Rezoning Transportation Analysis
Petition Number: Insert Zoning Petition #2021-226
General Location Identifier: 02902129, 02902130

Revision Log:

Date	Description
02-24-22	First Review (PDM)
03-24-22	Second Review (PDM)

**REZONING  
PLAN NOTES**

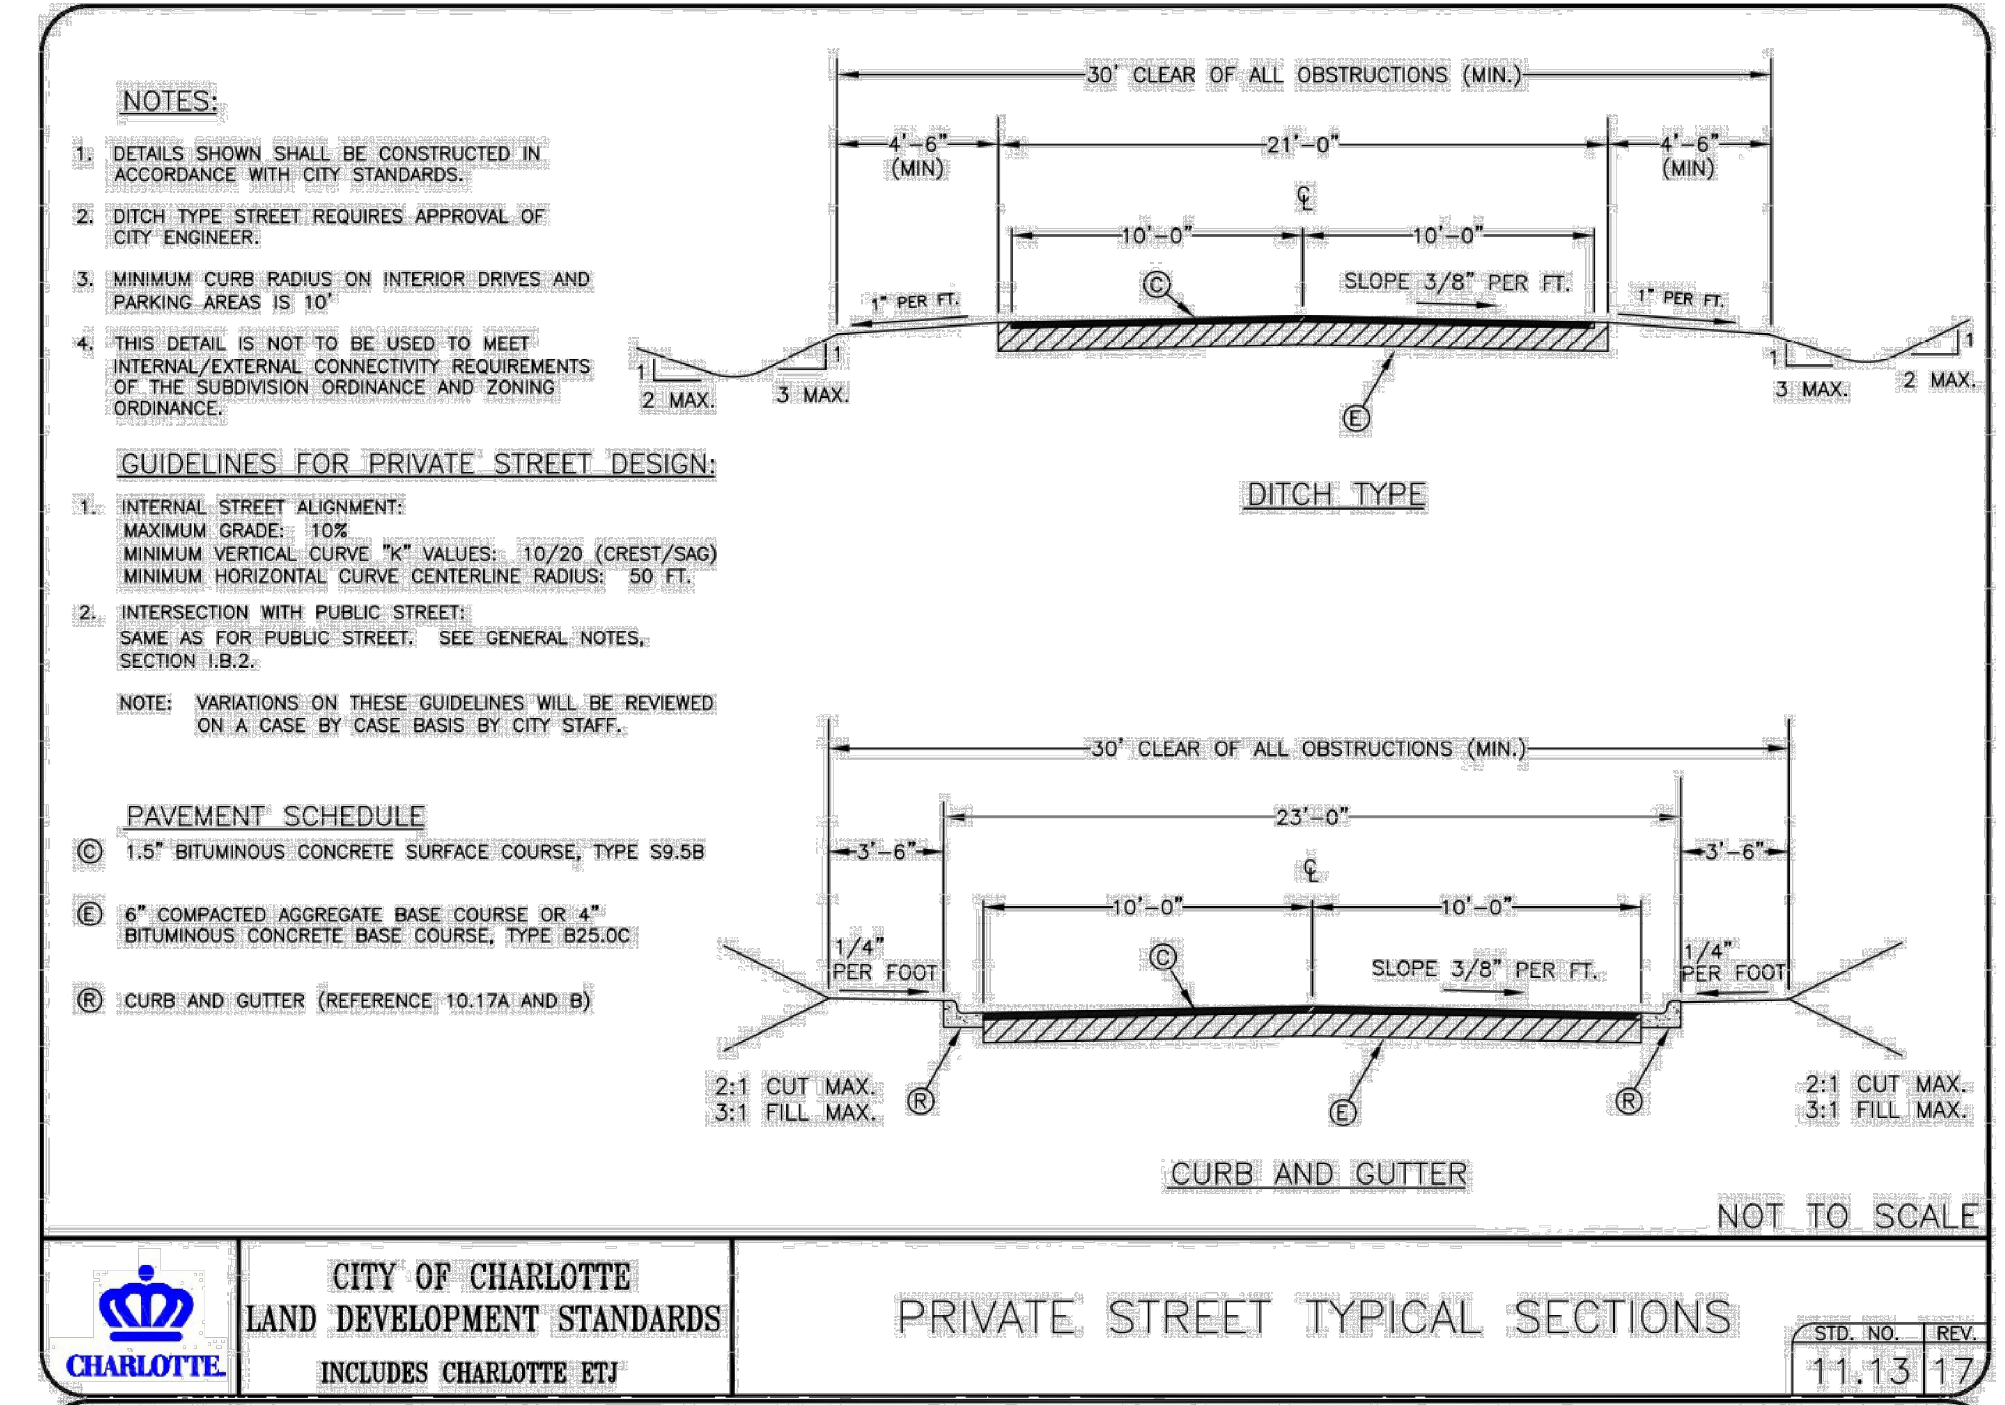
9. Remove conditional note 3.G.

Outstanding Comment from 02.24.2022: Remove language from conditional note 3.H per the markup below.

- h.** The Petitioner will construct all required roadway improvements and provide any required sidewalk and utility easements needed for these improvements prior to the issuance of the first certificate of occupancy, ~~subject to the Petitioner's ability to request that CDOT allow a bond to be post for any roadway improvements not finalized at the time of the issuance of the first certificate of occupancy, as allowed by City regulations.~~

**REZONING PLAN**

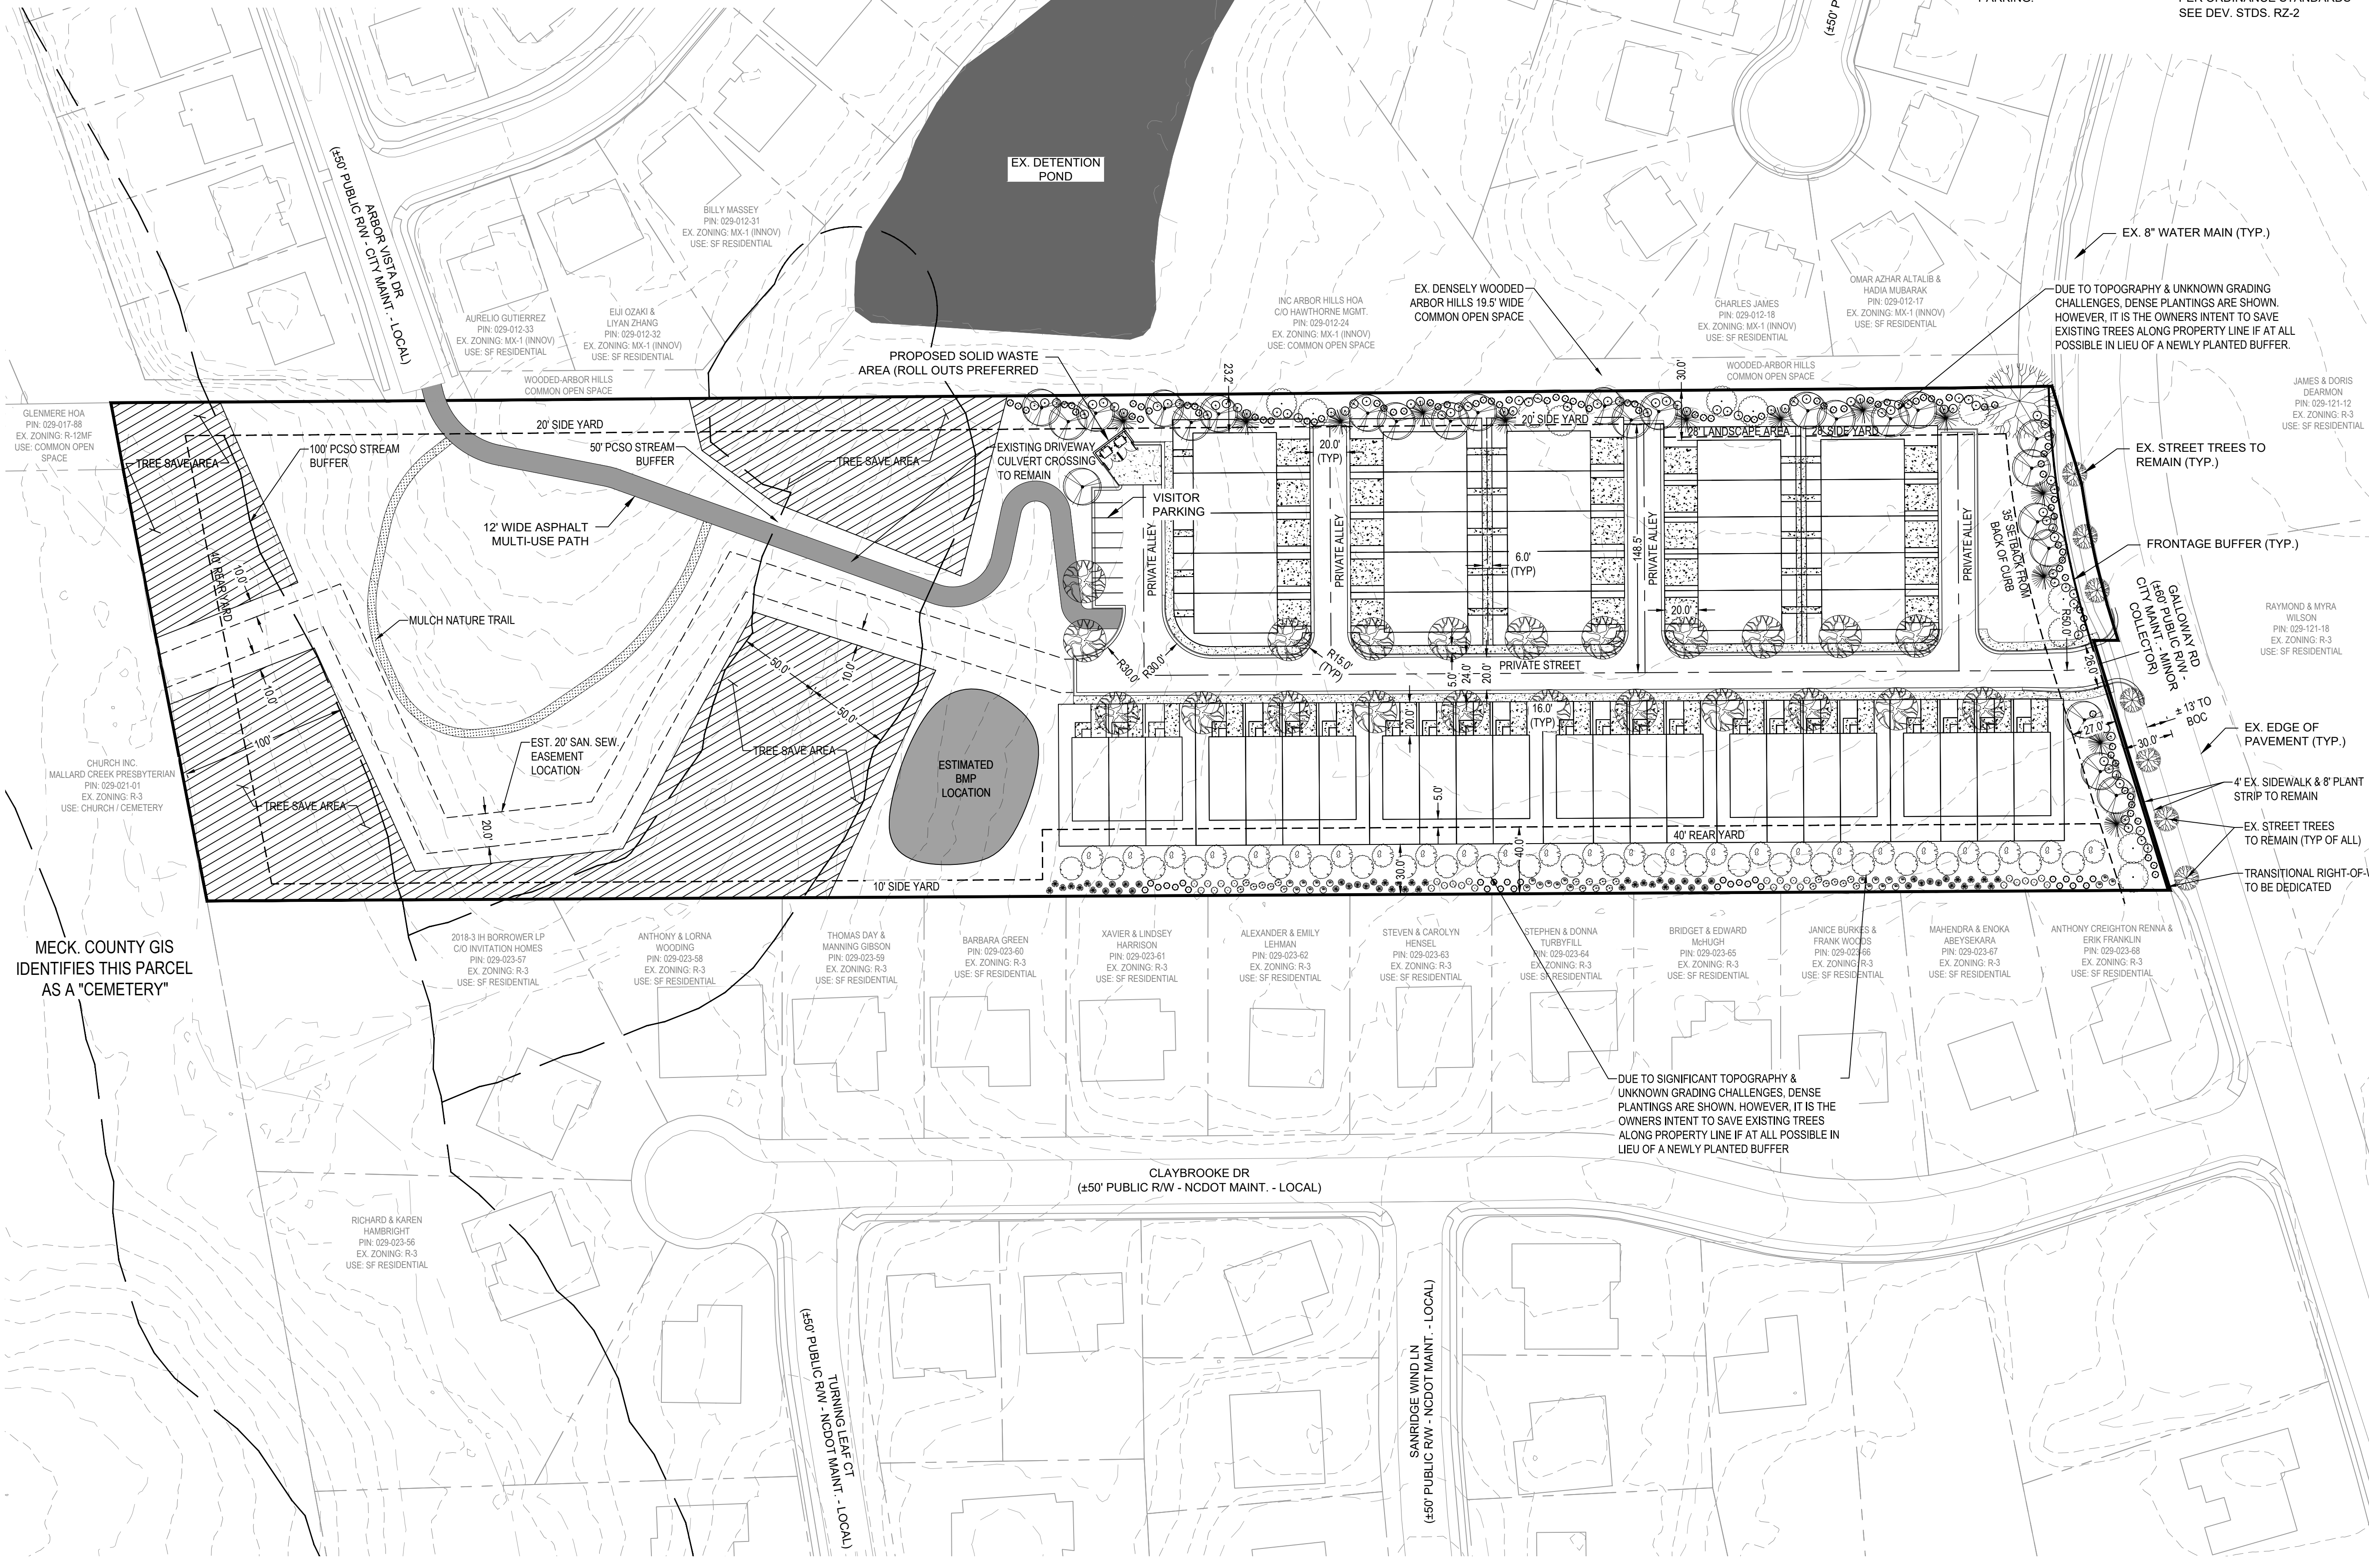
2. Revise site plan and conditional note(s) to commit to dedicate 30-feet of right-of-way from the road centerline of Galloway Road. The site plan shall label and dimension the right-of-way from the road centerline. Callout the proposed right-of-way line as "Proposed ROW."

Outstanding Comment from 02.24.2022: Add centerline of roadway to Galloway Road and callout the proposed right-of-way line as "Proposed ROW".

3. **Outstanding Comment from 02.24.2022:** Revise site plan to show the proposed 8-foot sidewalk and 8-foot planting strip located along Galloway Road per the conditional note 4.B.

- Revise site plan and conditional note(s) to commit to construct a 12-foot multi-use path that connects the Arbor Vista Drive stub street to the proposed street per Chapter 20. Provide a public access easement for the multi-use path route. CDOT may request the existing Arbor Vista Drive be extended with a public road if the existing building will be removed.

Outstanding Comment from 02.24.2022: Provide a public access easement for the multi-use path route. In addition, CDOT recommends stairway/path connecting MUP.

- 6. **Outstanding Comment from 02.24.2022:** Revise site plan to provide a minimum 50-foot stem between the proposed right-of-way and the first residential driveway. Dimension stem length.

- 7. **Outstanding Comment from 02.24.2022:** Revise site plan to provide curb ramps for the sidewalk along Galloway Road crossing the proposed private street.

- 8. Revise site plan to show the entire section of Galloway Road existing curb and gutter along the property frontage. Label and dimension the curb and gutter front the centerline of the road.
